Engineers comments for R/149/12/

APPLICATION R/149/12/

Site Address: Focus, Unit A New Road Rustington BN16 3RT

Description of Works: Alterations to car park layout, access and landscaping

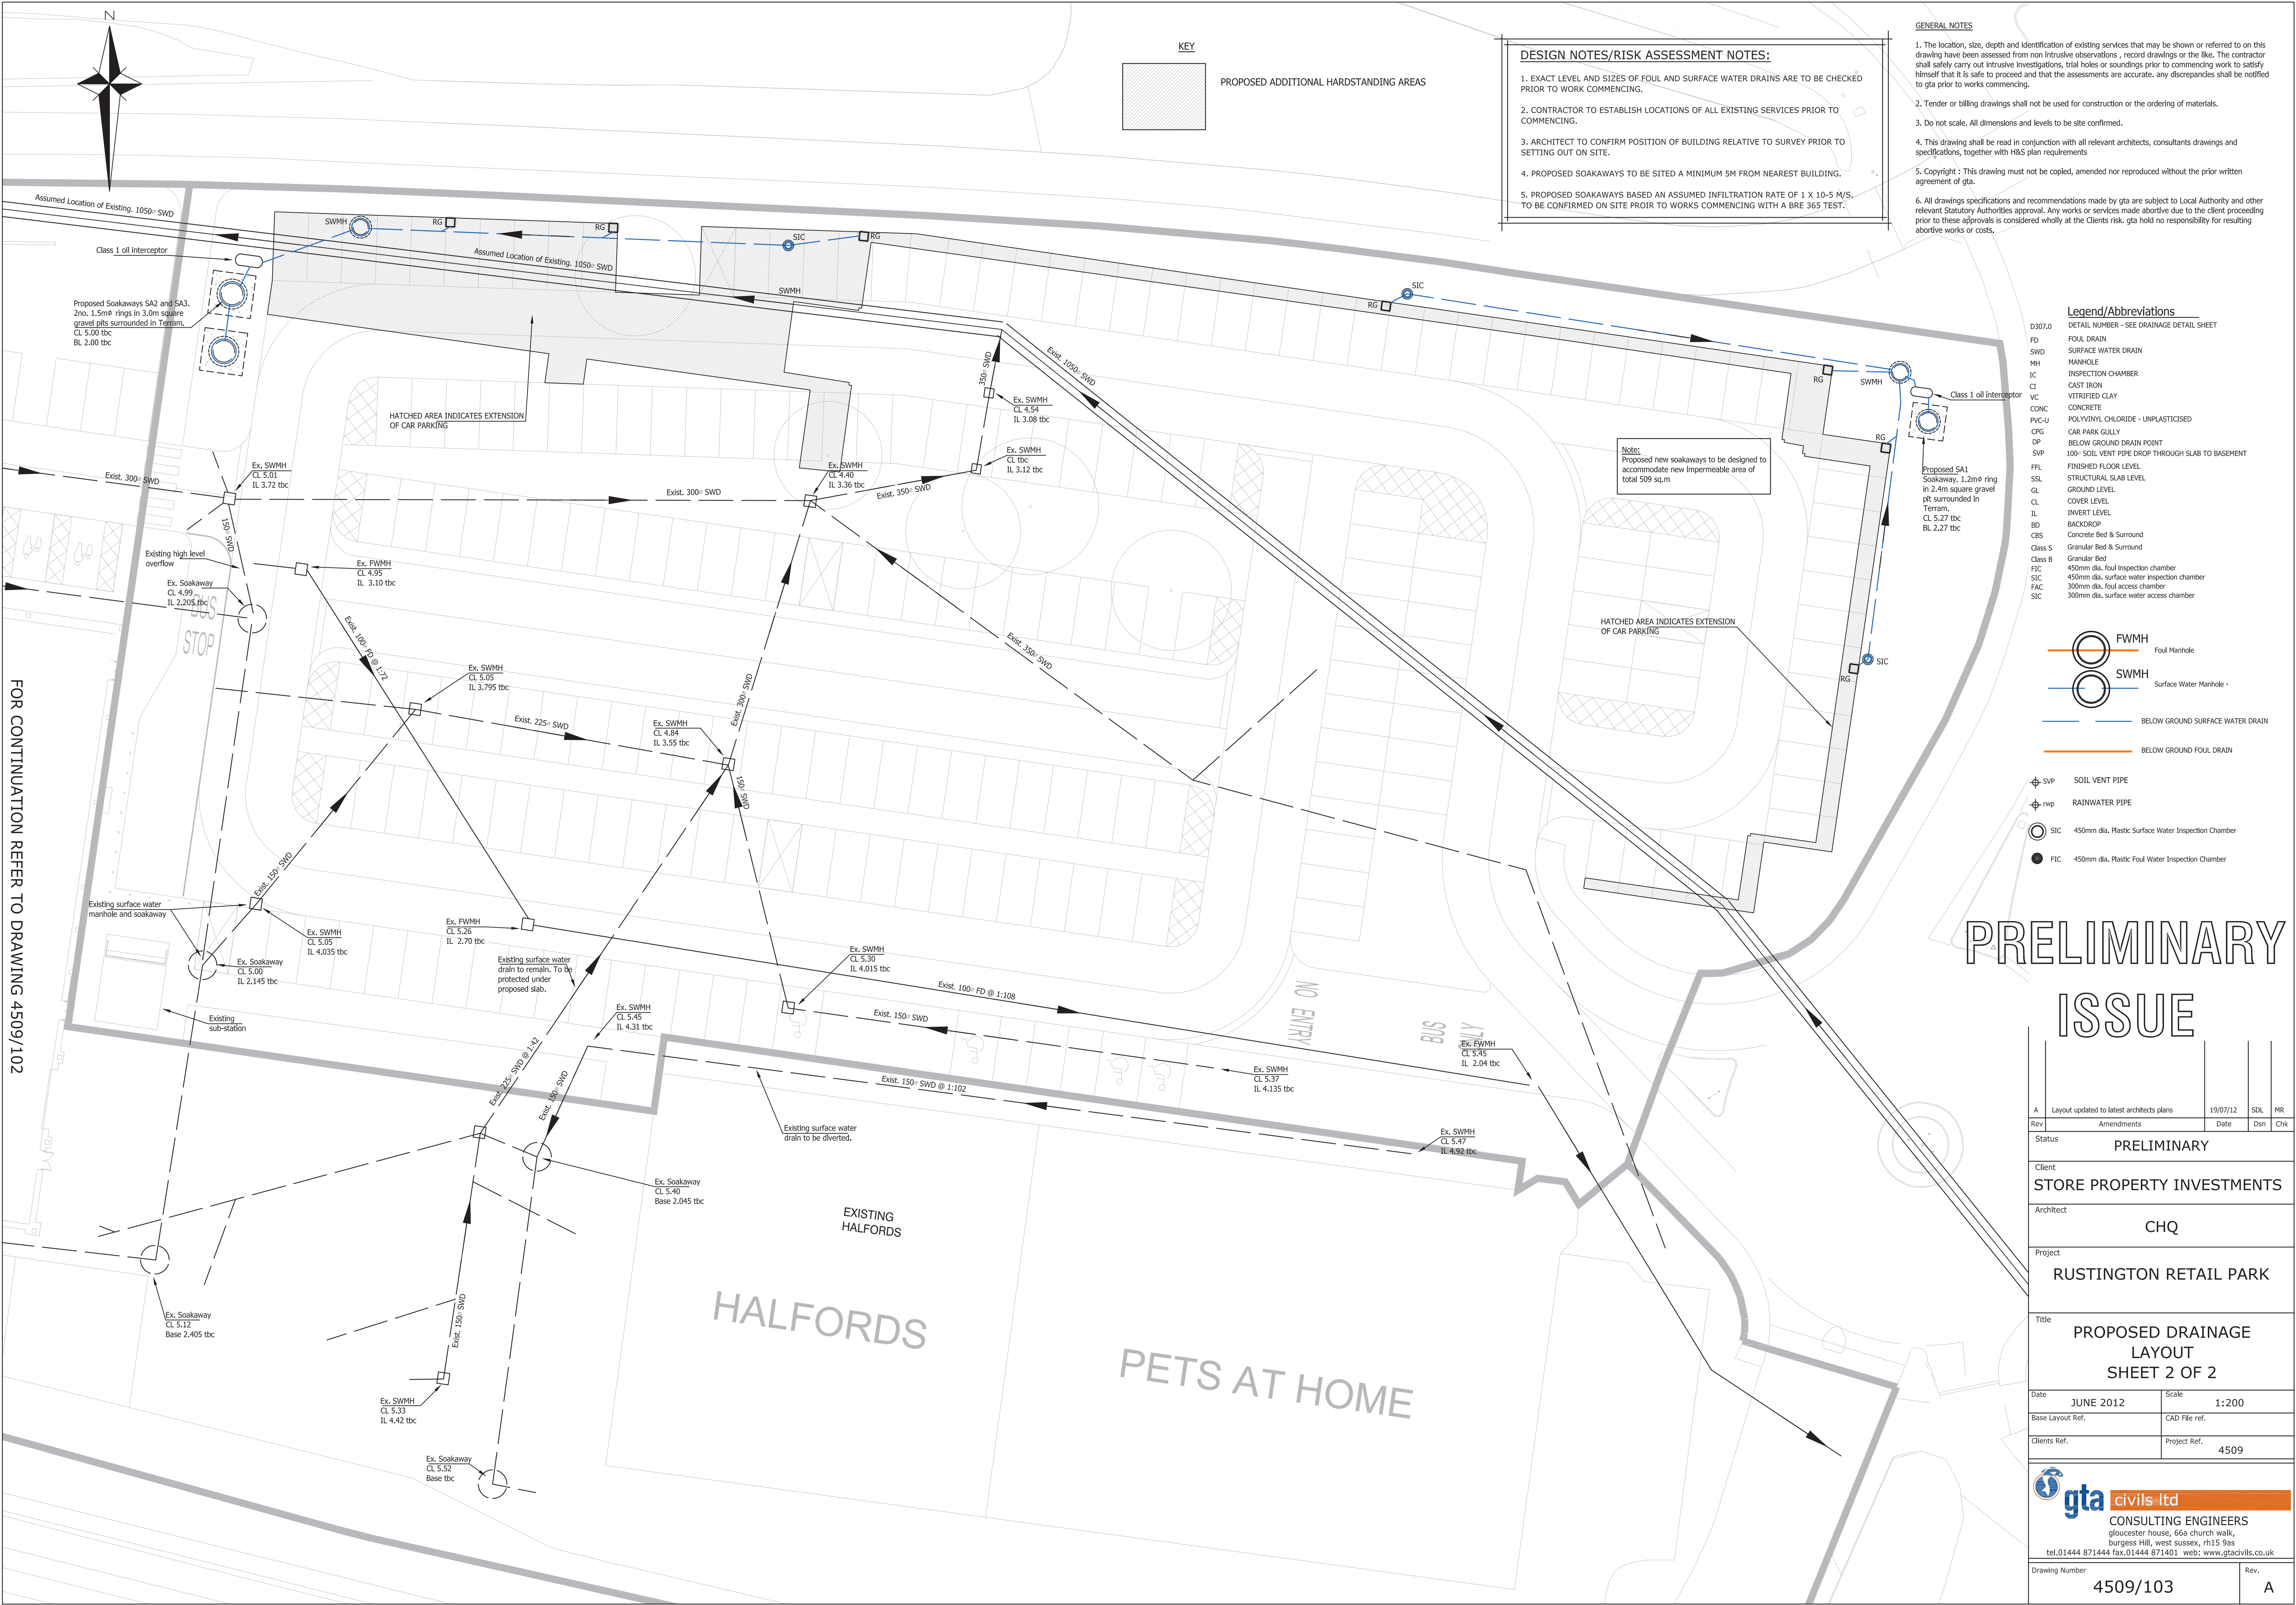
Proposal for soakaways is acceptable in principle, However, the Sainsbury's site to the East of this has informed us that soakaways may not be possible on the site. Full ground water monitoring and Percolation testing will be required to support any infiltration design. This must be completed and approved before ANY construction takes place. I suggest the following condition is applied

Winter groundwater monitoring to establish highest annual ground water levels and Percolation testing to BRE 365, or similar approved, will be required to support the design of any Infiltration drainage.

Development shall not commence until full details of the proposed surface water drainage scheme have been submitted to and approved in writing by the Local Planning Authority.

The design should follow the hierarchy of preference for different types of surface water drainage disposal systems as set out in Approved Document H of the Building Regulations and the SUDS Manual produced by CIRIA.

No building shall be occupied until the complete surface water drainage system serving the property has been implemented in accordance with the agreed details.
